**WELWYN HATFIELD BOROUGH COUNCIL
EXECUTIVE DIRECTOR - PLANNING, PUBLIC PROTECTION AND GOVERNANCE**

Application No: 6/2018/2102/FULL
Location: Oak Cottage Residential Home 4 Wilkins Green Lane Hatfield AL10 9RT
Proposal: Retention of two storey rear extension
Officer: Ms Lucy Hale

Recommendation: Granted

TITLE
PROPOSED
GROUND & FIRST FLOOR PLANS
 ADDRESS
OAK COTTAGE CARE HOME,
4 WILKINS GREEN LANE,
HATFIELD, AL10 9RT.
 SCALE
1 : 100 @A2
 DATE
JUL 2019
 DRAWING NO.
OCCH 102-1
 REV.
A

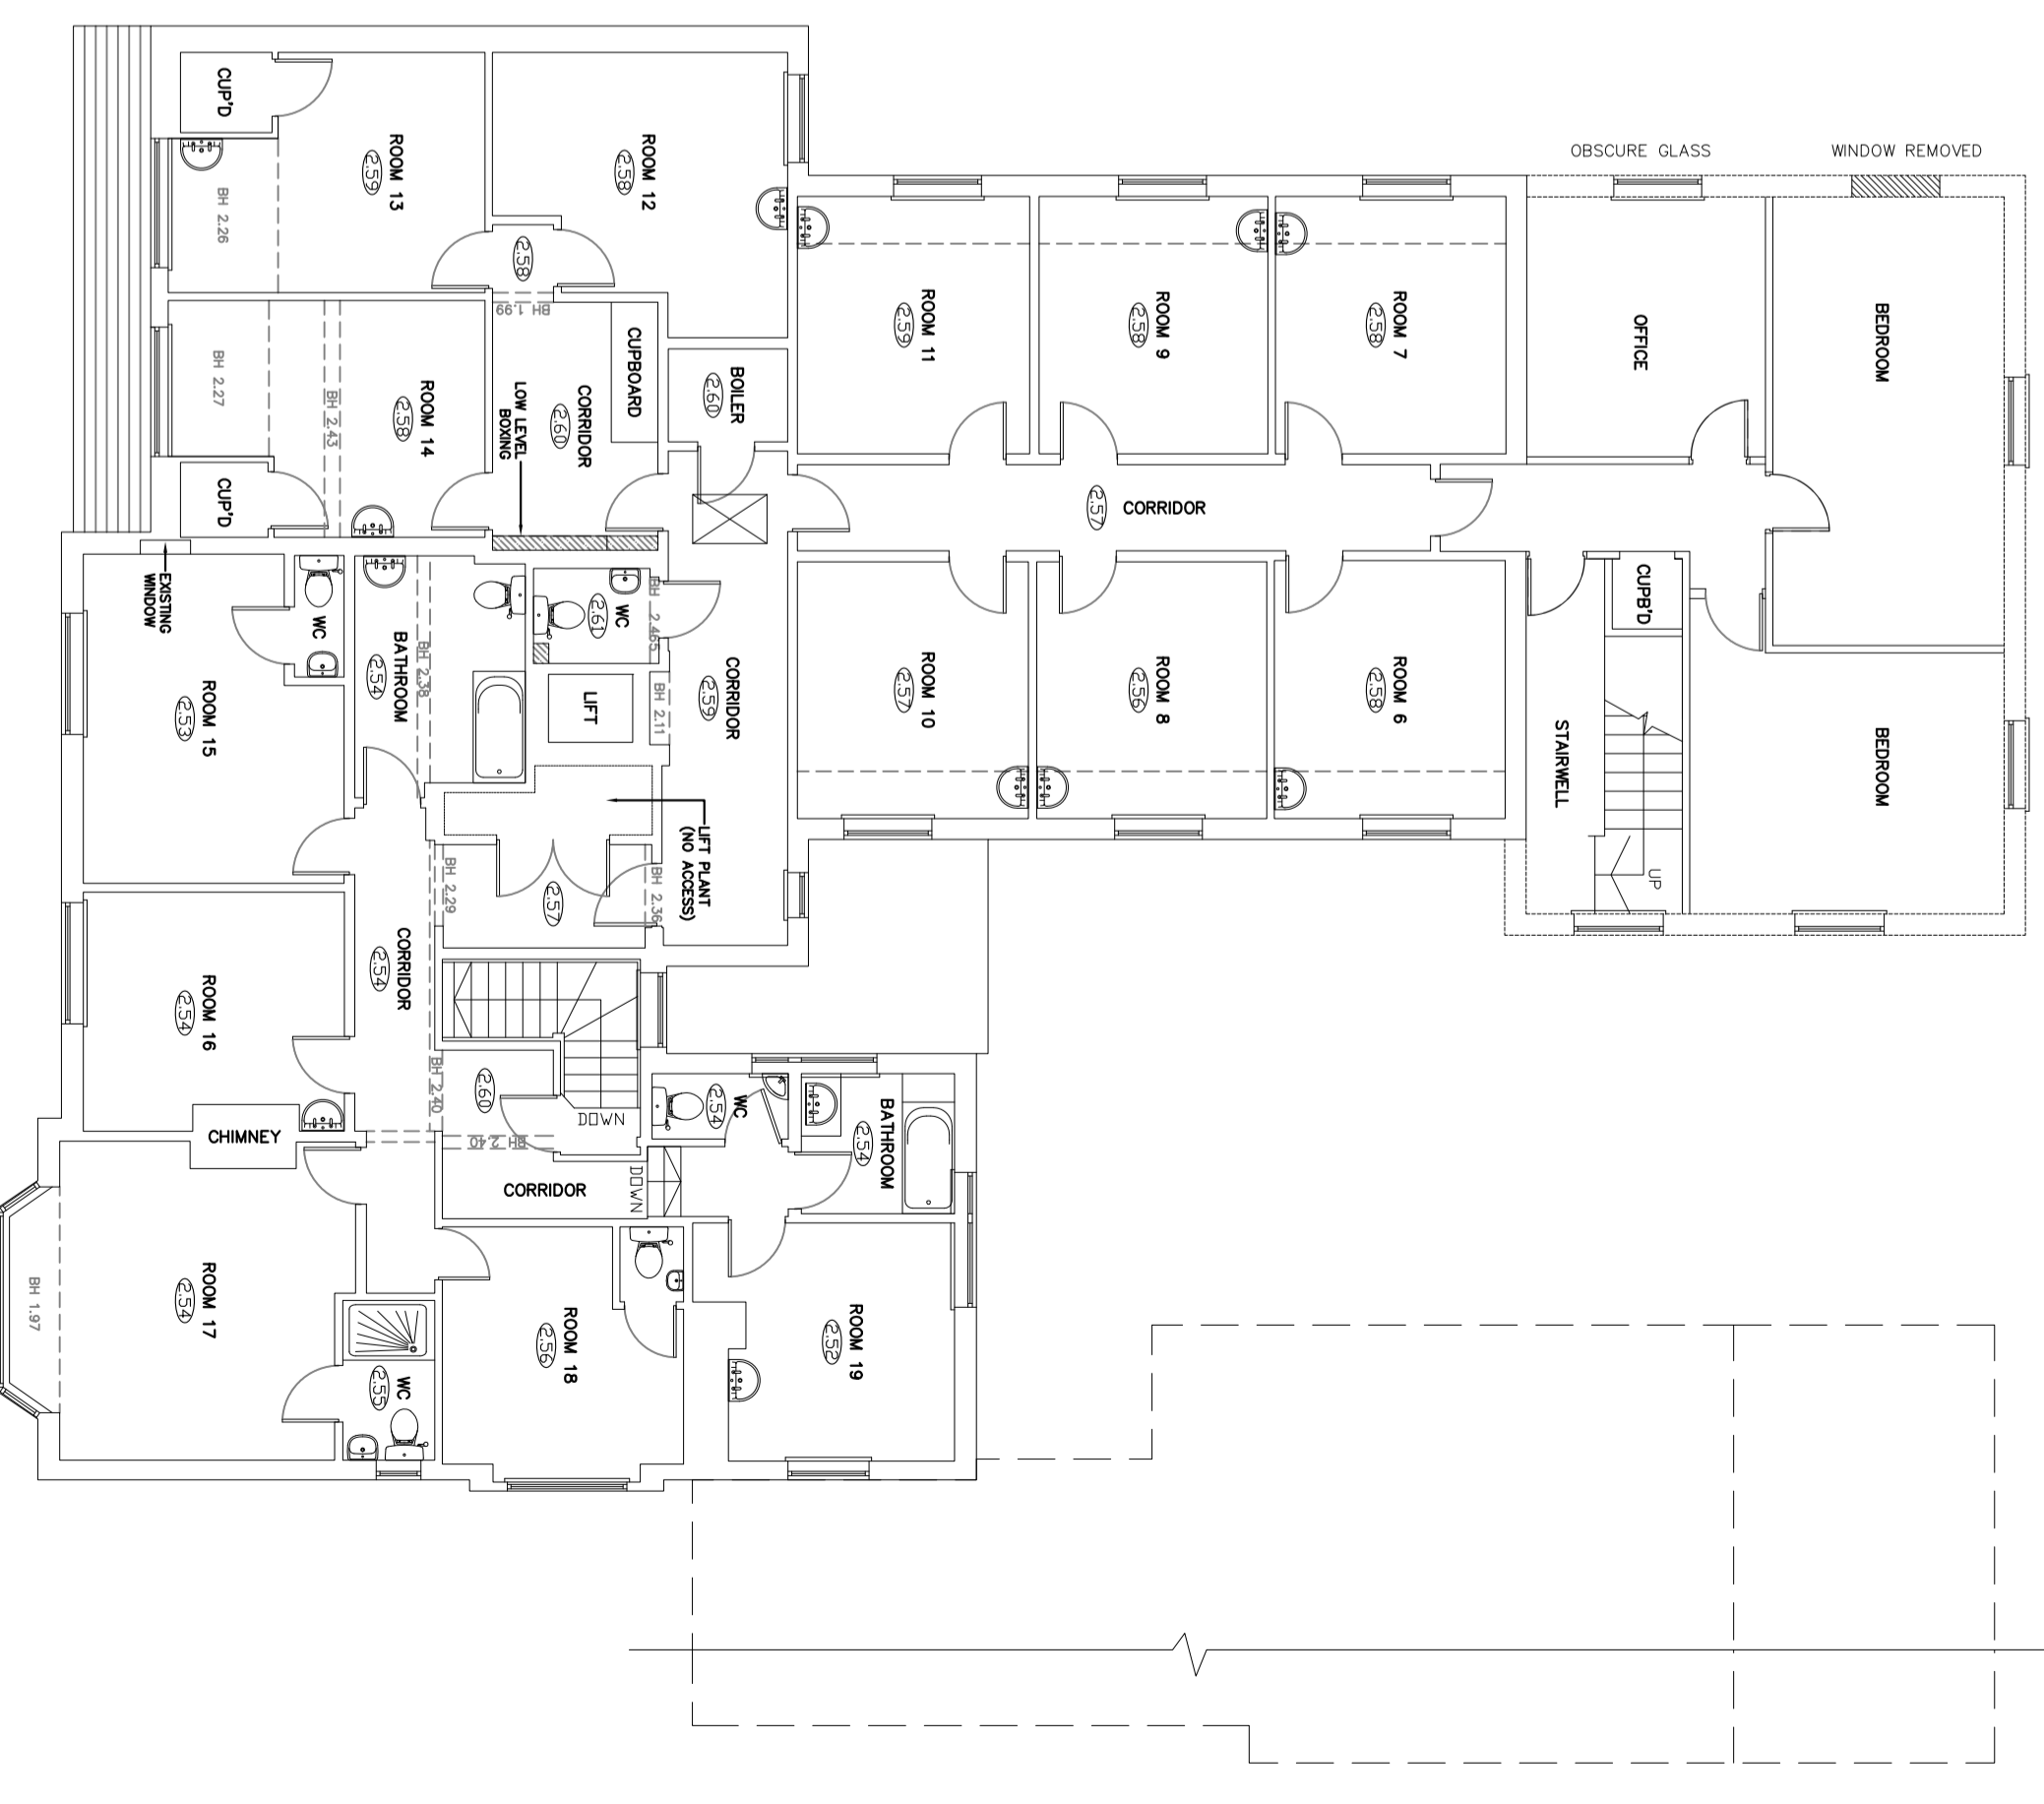
The internal floor layout has been amended since the last submission with the change of bedrooms to offices and lounges. As a result, the proposal would involve the creation of 3 additional bed spaces and 1 additional parking space is. In addition 4 more full time staff will require a further 2 parking spaces. This gives a total need of a maximum of 3 additional parking spaces.

As a result of the changes, the parking requirement would be based on 23 bedrooms and the equivalent of 17 full time members of staff. In accordance with the Council's maximum car parking standards, the site would require 15 spaces. It is therefore considered that sufficient off-street parking has been provided in accordance with the Council's SPG and Interim Parking Standards. The proposed development would meet the requirements of Policy M14 and CLT17 of the Welwyn Hatfield District Plan 2005.

1. The alterations to the building hereby approved and as shown on drawing numbers OCCH 102-1 Rev A and OCCH 102-2 Rev B dated July 2019 shall be commenced within 3 months of the date of this decision and be fully completed within 6 months of the date of this decision.
